**Forestry Corporation of NSW** ABN 43 141 857 613  
**Western Region**  
Cnr Monash and Chelmsford Streets  
Dubbo NSW 2830  
(PO Box 865 Dubbo NSW 2830)  
T: 0410 149 385  
E: jarod.dashwood@fcnsw.com.au  
[www.forestrycorporation.com.au](http://www.forestrycorporation.com.au)

21 June 2018

**RE: NARRABRI GAS PROJECT ENVIRONMENTAL IMPACT STATEMENT (SSD 6456) –  
REVIEW OF RESPONSE TO SUBMISSIONS - DRAFT**

Figure 28-1 Estimated volume of drill cuttings per year

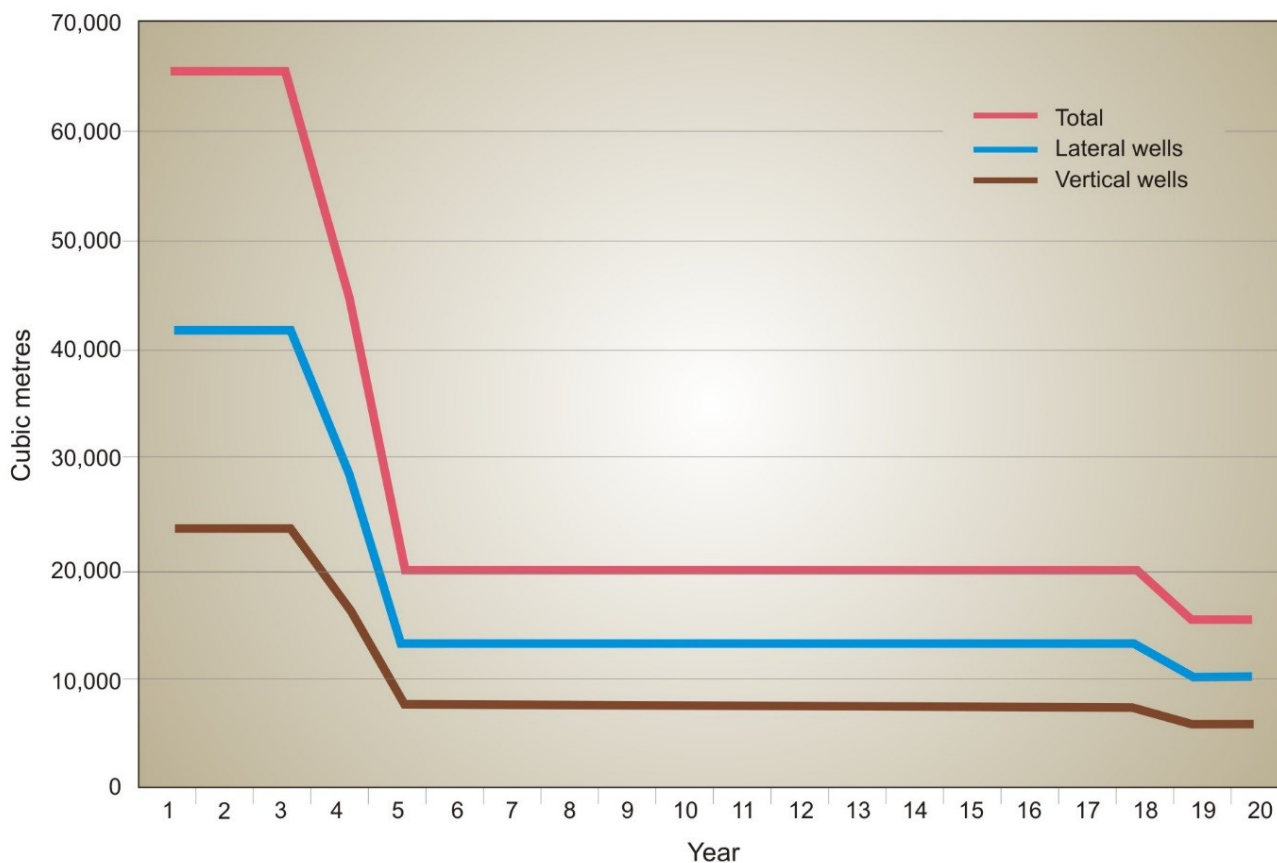
No evidence is presented in the EIS that the incorporation of drilling spoil into the surface soil profile will provide benefits to FCNSW or the receiving environment.

The RTS describes the reuse of rock based drill cuttings at existing appraisal wells. It is unclear from the RTS which appraisal wells these are. No evidence accompanies the RTSs claim that the incorporation of drill cuttings leads to more successful rehabilitation outcomes than sites where drill cuttings are not used. Quantitative sampling with comparison against control sites would be necessary to demonstrate the degree of benefit the incorporation of drill cuttings offers to the receiving environment and the landholder.

The RTS introduces the possibility of beneficial reuse of coal cuttings – further information is necessary for FCNSW to determine the appropriateness of reuse within State forest.

The RTS states that rock-based drill cuttings not appropriate for use on well pads will be transported to a licenced waste management facility. FCNSW asks that Santos disclose details of any historic offsite disposal of rock-based drill cuttings produced on State forest, and describe what characteristics determined that the cuttings were inappropriate for use on well pads.

The RTS does not describe how non-beneficial waste cuttings are to be removed from site at decommissioning/prior to rehabilitation.

FCNSW suggest that project approval conditions require the proponent to prepare a drill cutting utilisation strategy to the satisfaction of FCNSW within 12 months of the date of this approval. The strategy would include where and how drill cuttings would be utilised on State forest, material tracking system to facilitate removal at decommissioning, and conditions for the suitable abandonment of cuttings in State forest.

Should Santos wish to use the drill cuttings for construction purposes, Santos should manage the material in a manner such that it may be accounted for and then removed from State forest at the cessation of the Project.
